From: [REDACTED]
To: [REDACTED]
Subject: Re: 6/2015/1724/EM
Date: 18 December 2015 13:15:01

Dear Sir or Madam, Please find attached a notification regarding an application that has been submitted to the Council for determination. Full details are within the letter.

Proposed Front Garden Post & Rail
Fence

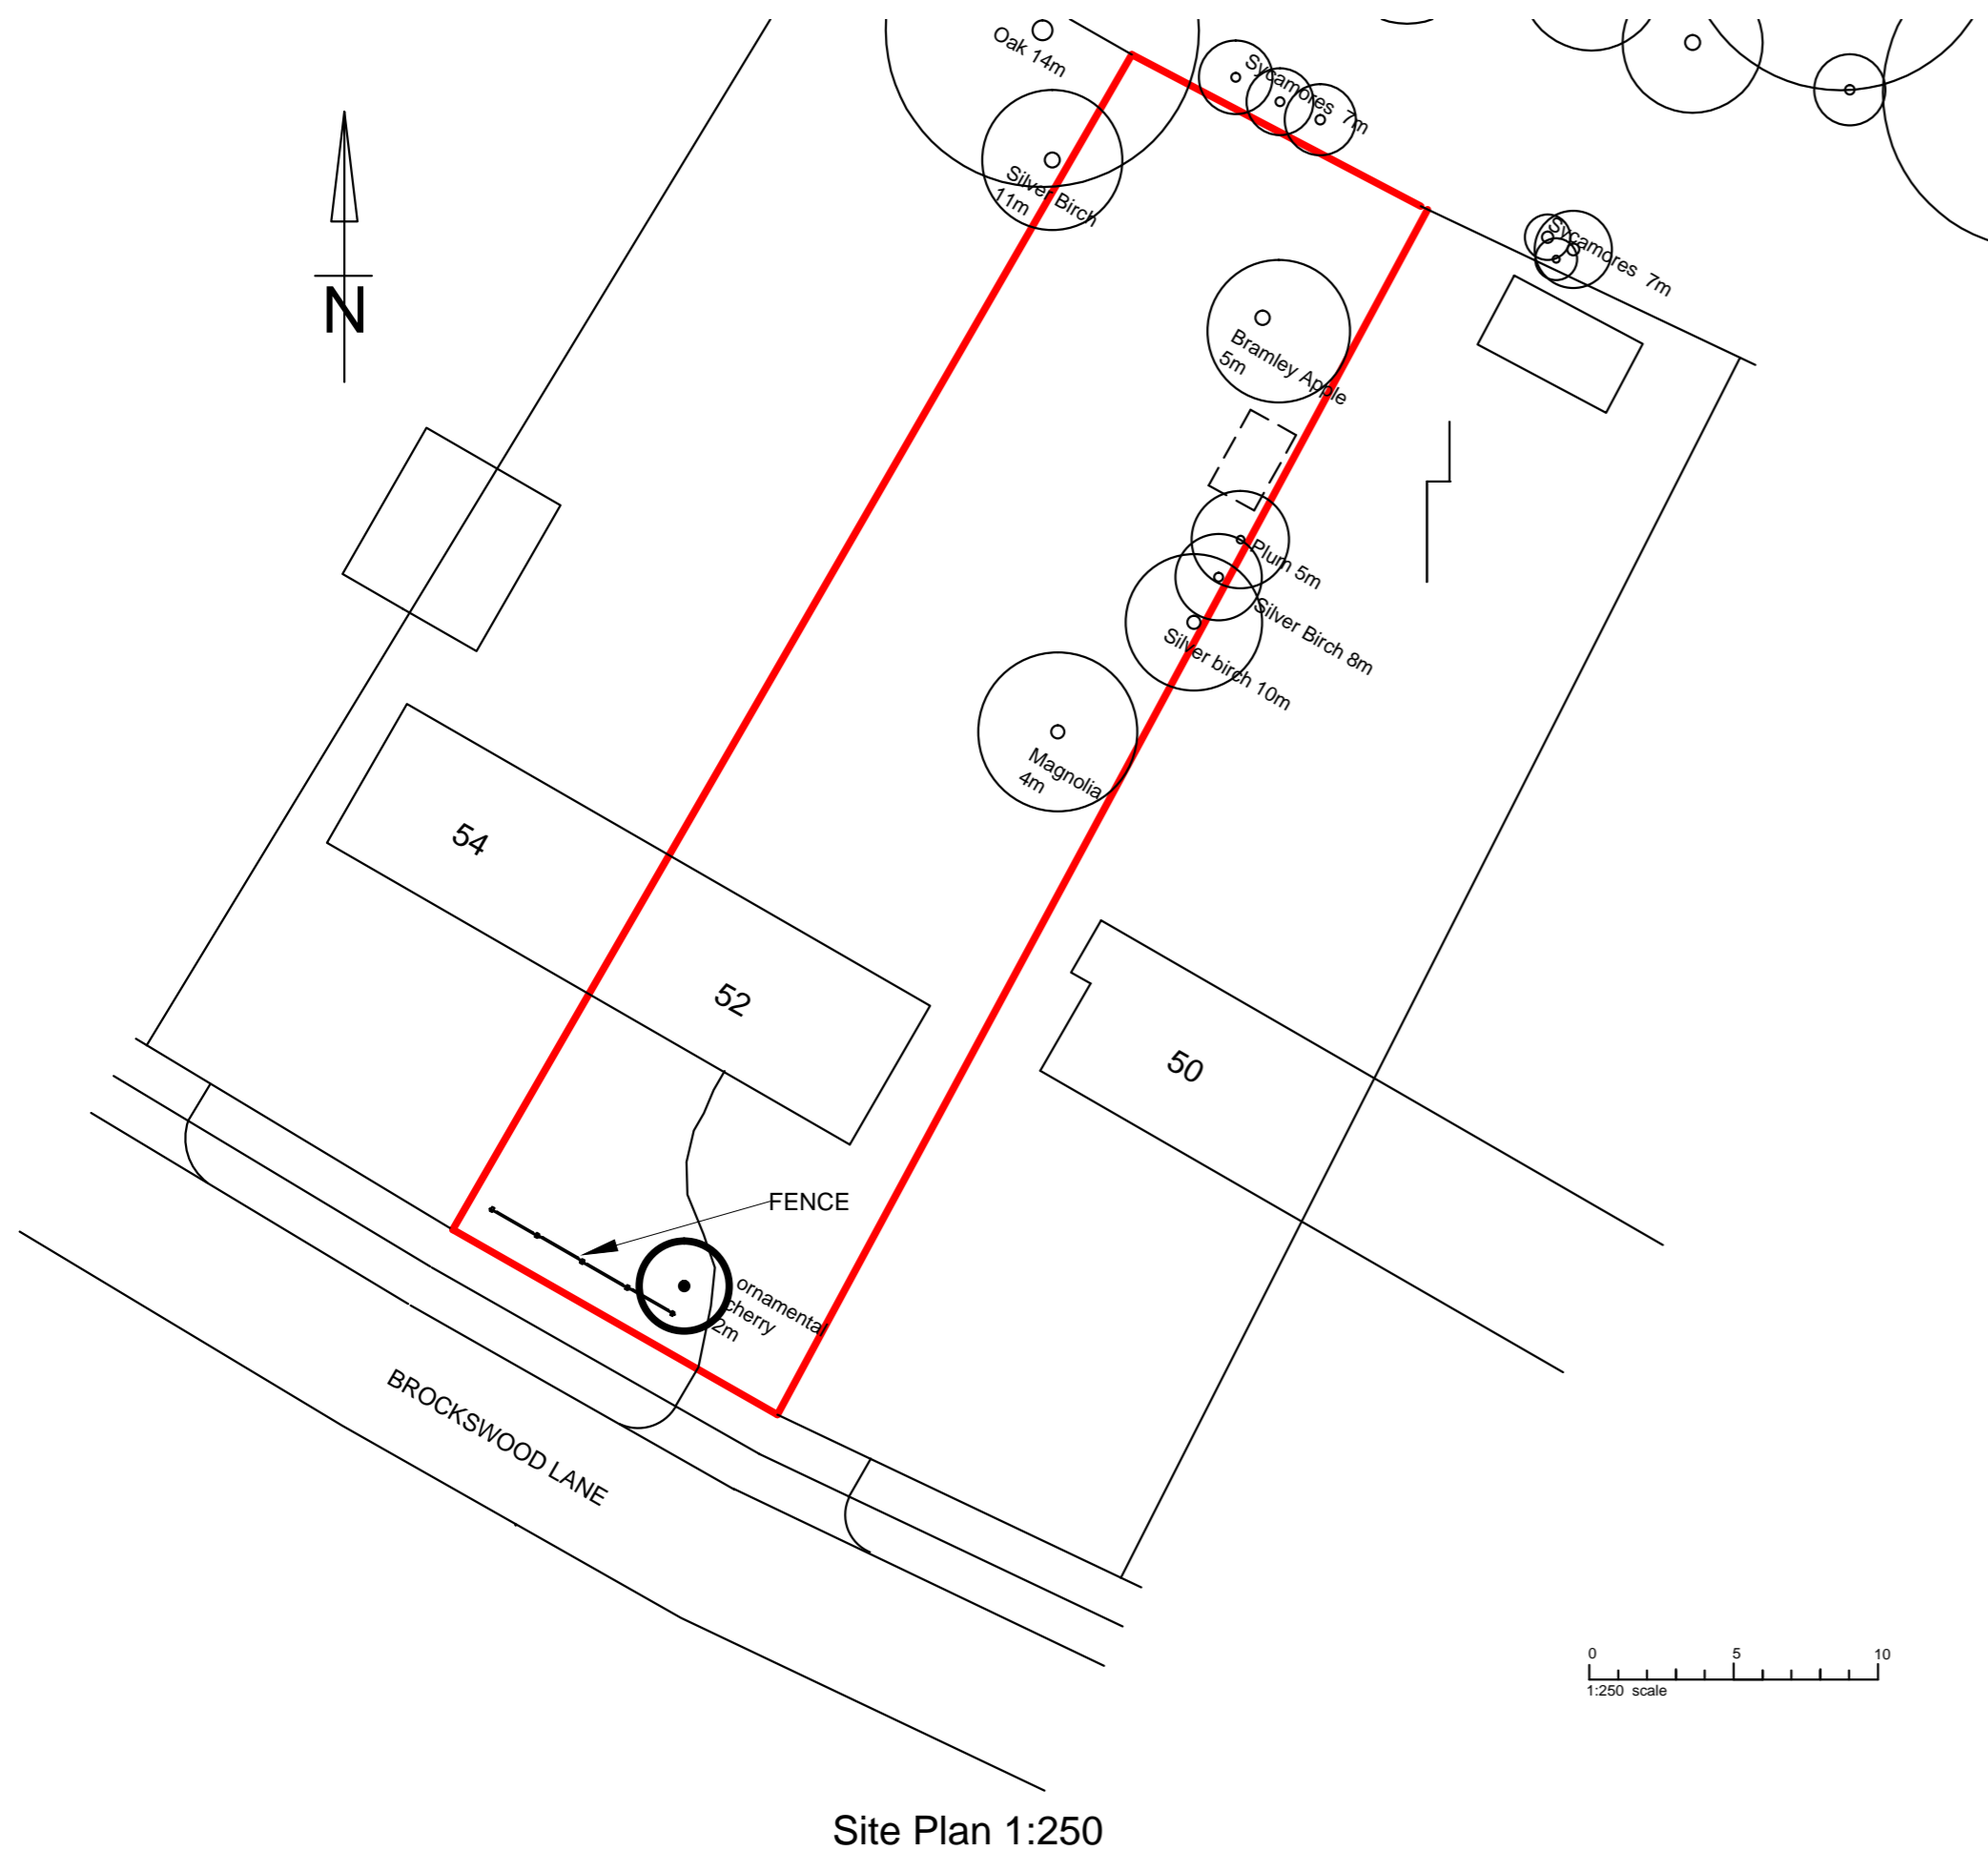
I would hope that we are telling the resident that there should be a hedge here?
